APPROVED
Licensed building and safety
Permit holder responsible for
full compliance with the code.

H&H HOMES, INC.
WILMINGTON

C - ELEVATIONS
A-3

**FRONT ELEVATION-C**  
SCALE: 1/4" = 1'-0"

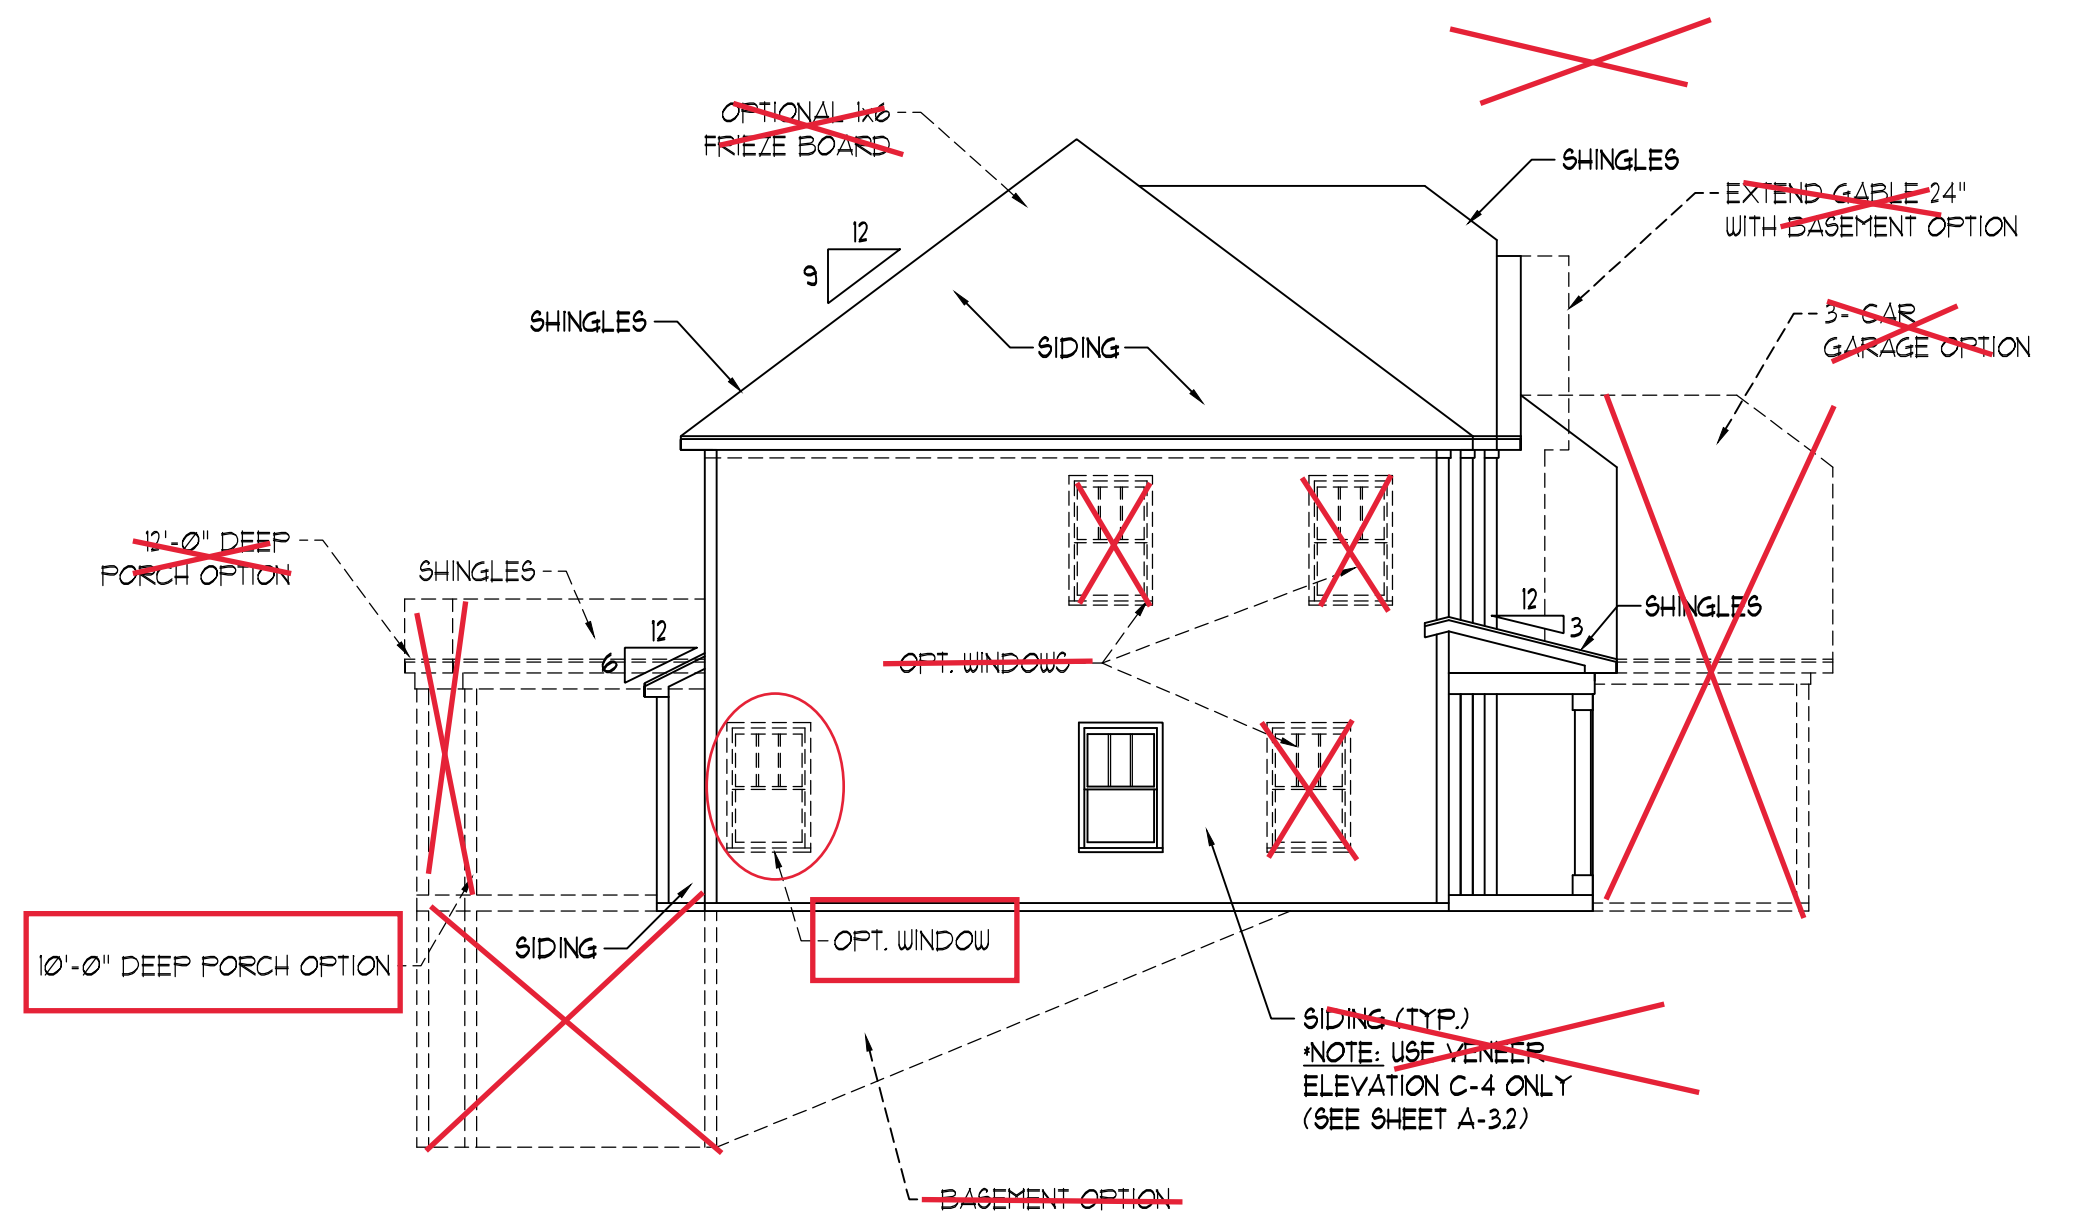
REPLACE ALL 3/0 5/0 AND 3/0 6/0
WINDOWS WITH 2/8 5/2
WINDOWS
